December 21, 2021

Cassandra Durkin, CPESC, CESSWI  
Inspections Plus Inc.  
504 El Paraiso Rd. NE Suite B  
Albuquerque, NM 87113

**Re: Allaso Vineyard Apartments - 8945 Holly Ave NE  
Erosion and Sediment Control Plan  
Engineer's Stamp Date 12/16/2021 (C20E086)**

*TEMPORARY EROSION AND SEDIMENT CONTROL PLAN*

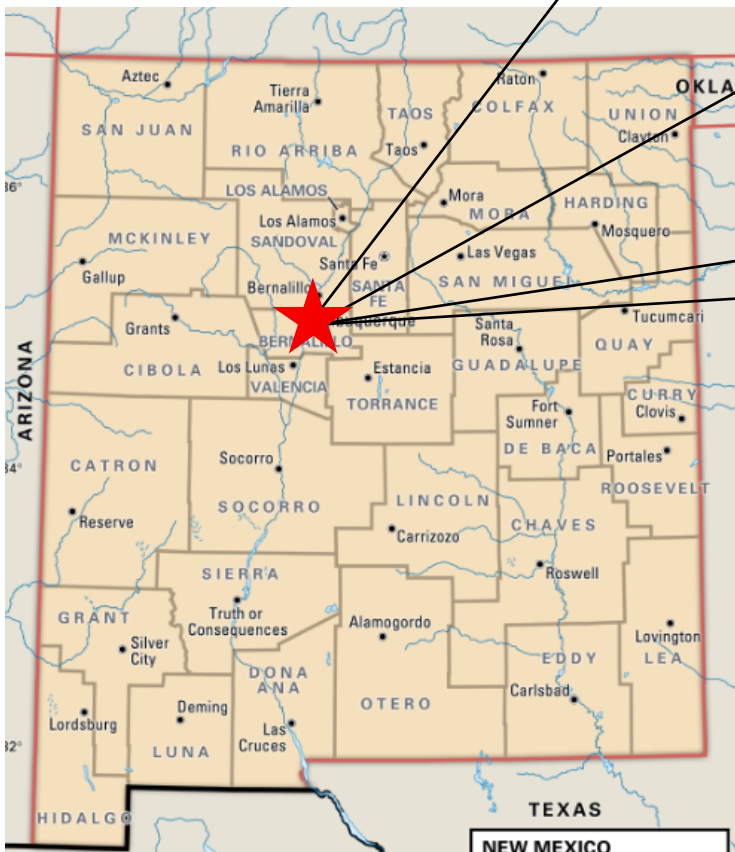
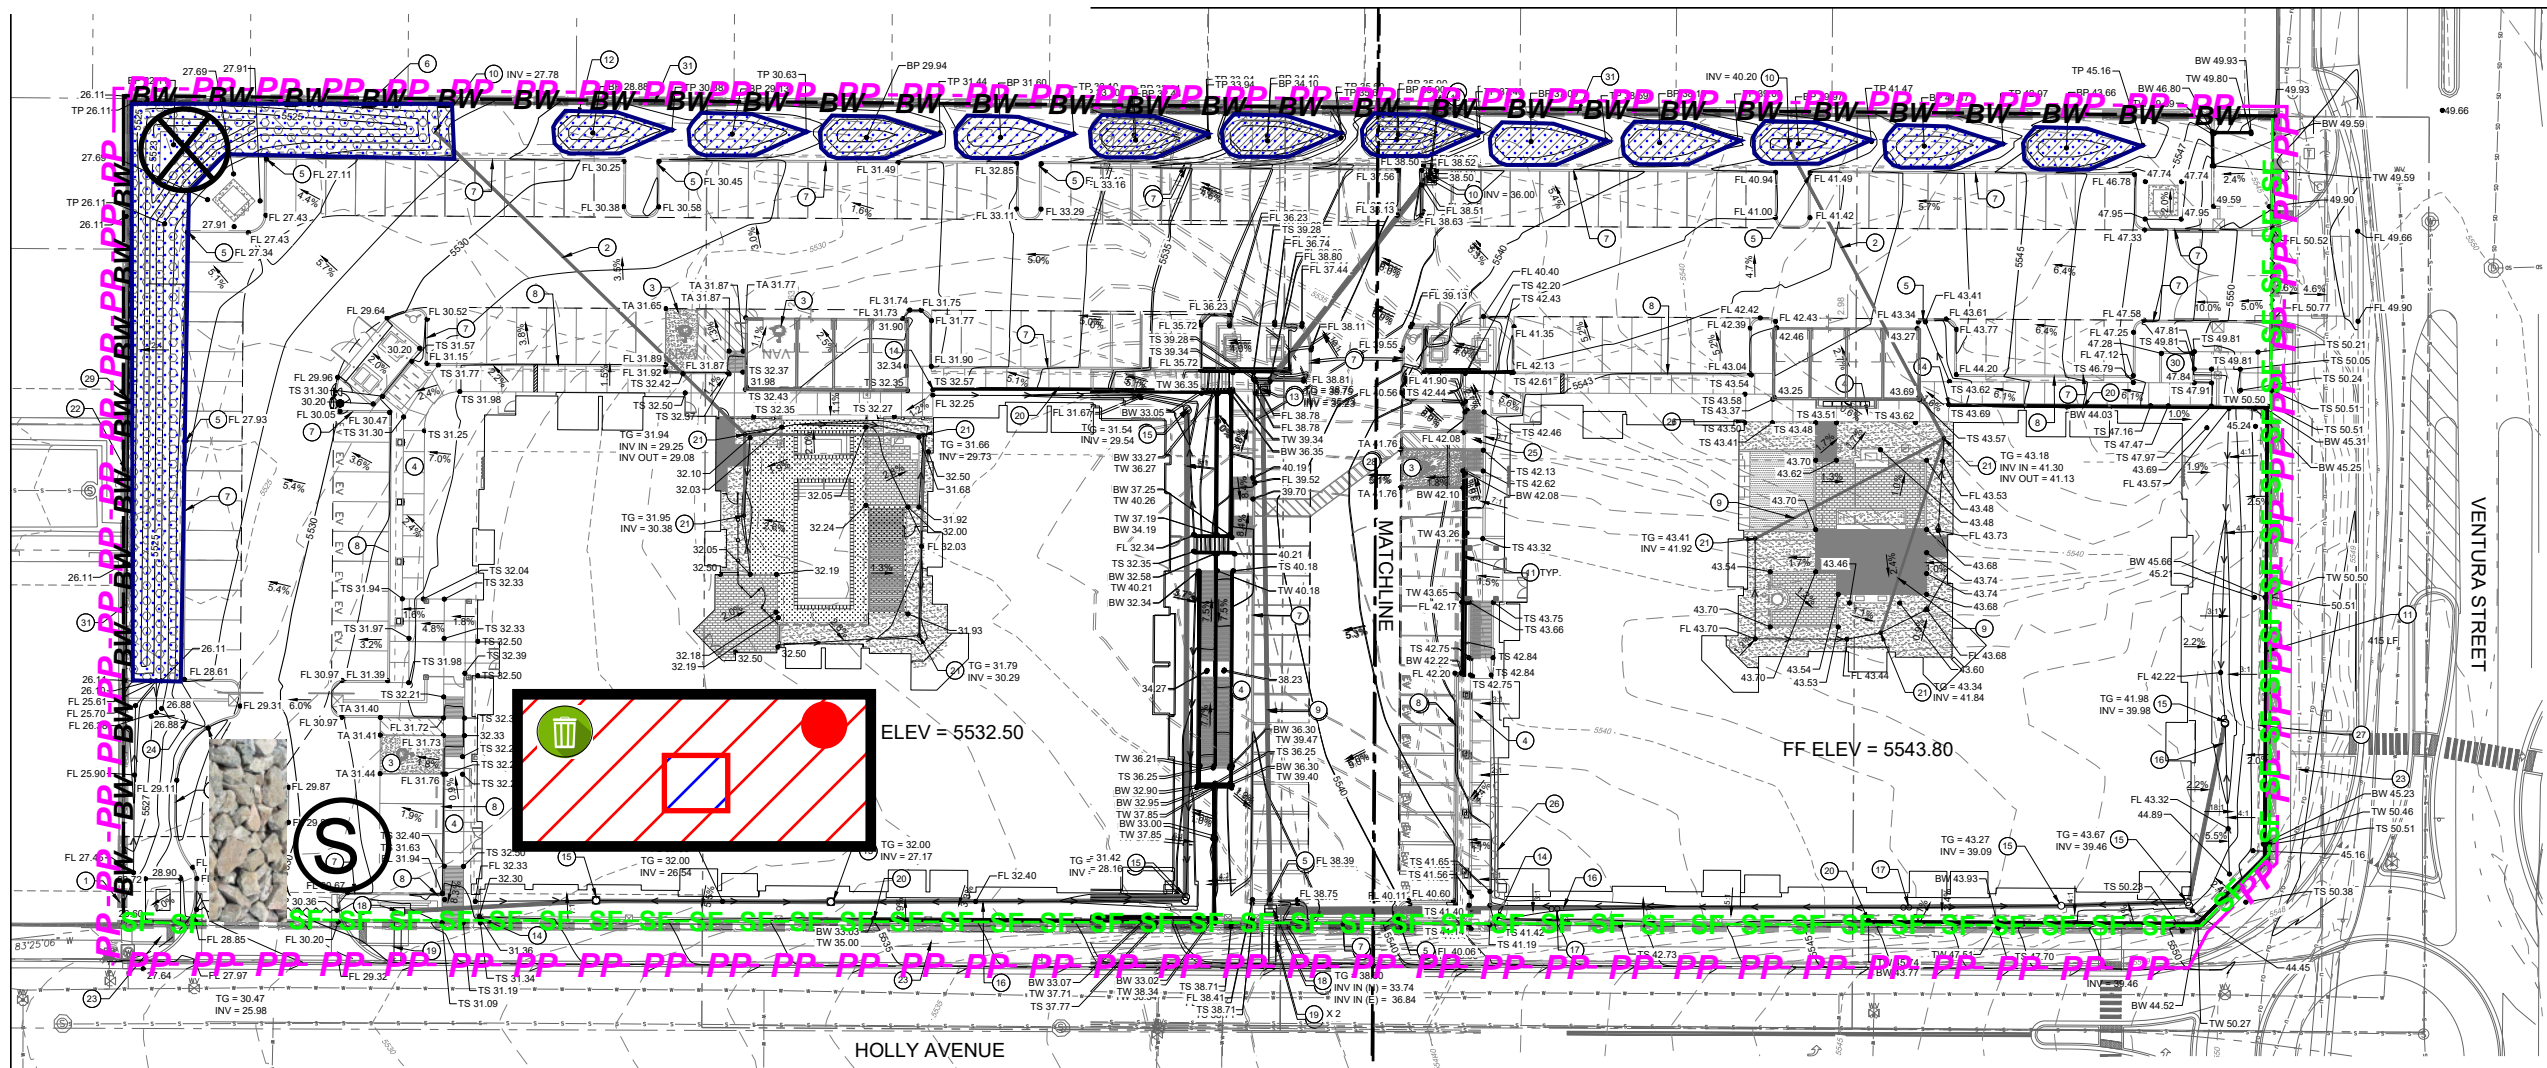
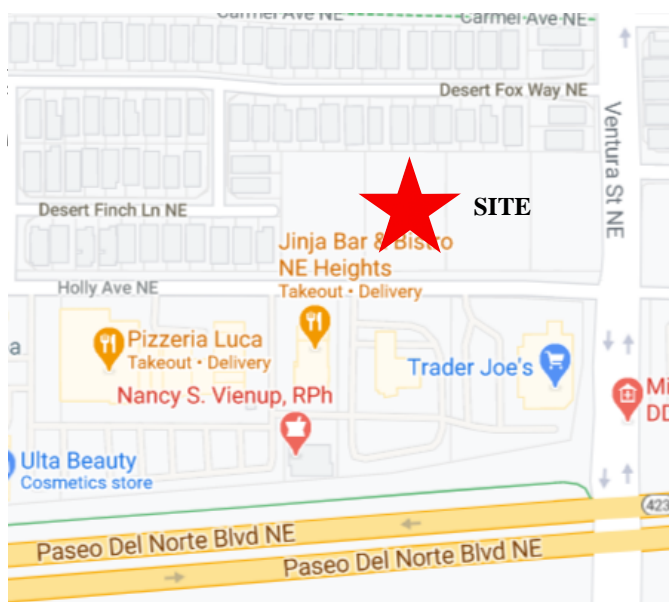
1. The limits of disturbance must be shown on the ESC Plan (CGP7.2.4.b.i). The limits must include both the Building Permit (3.3ac) and the Work Order (1.5ac). Lot lines must also be shown.

2. The ESC Plan can't be approved until after Hydrology approves the G&D Plan. The existing and proposed grades must be shown on the ESC Plan, and they must agree with the Grading Plan approved by Hydrology (CGP7.2.4.b.ii)

3. Identify locations of concentrated flow paths that enter and exit the disturbed areas. The locations on the ESC Plan don't agree with the locations on the G&D Plan. Show on-site drainage patterns of stormwater before and after major grading activities. (CGP7.2.4.f)

4. The SWPPP must include site-specific interim and permanent stabilization per CGP 9.4.1.c.i. The landscape plan can be used to satisfy this requirement and should be included in the SWPPP and the ESC Plan submittal.

5. I can't tell the difference between building, sidewalk, asphalt, and dirt on the ESC Plan. These structures must be clearly identified in the SWPPP per CGP 7.2.4.b.v. The same information is required in the ESC Application. You may include a copy of the Site Plan in both the SWPPP and in the ESC Application to address this requirement.

6. Describe the nature and extent of construction activities for both onsite and offsite operations (CGP 7.2.2.), including a) nature of construction activities, b) size of the property, c) size of disturbed area, d) description of construction support activities if any, e) size of maximum disturbed area, and f) Project Schedule both onsite and offsite The offsite demolition, wattles, and onsite sediment trap are missing from the schedule.

7. The ESC Plan must include site-specific erosion and sediment control best management practices (BMPs) that are designed to prevent to the maximum extent practicable an increase in the sediment yield. The ESC Plan must identify and document the rationale for selecting these BMPs including:
  - a. A temporary sediment trap at the outfall on the west side of the site per CGP 2.2.12 including volume calculations.
  - b. A cutback swale with j-hook silt fence along Holy Ave. since it exceeds 2.5% slope.
  - c. Mulch socks for the Work Order construction activities.
8. Soil information – add a table with name type, particle sizes, and Erodibility factor (CGP 2.1.1).
9. Update the engineer's stamp date each time the plan is changed.
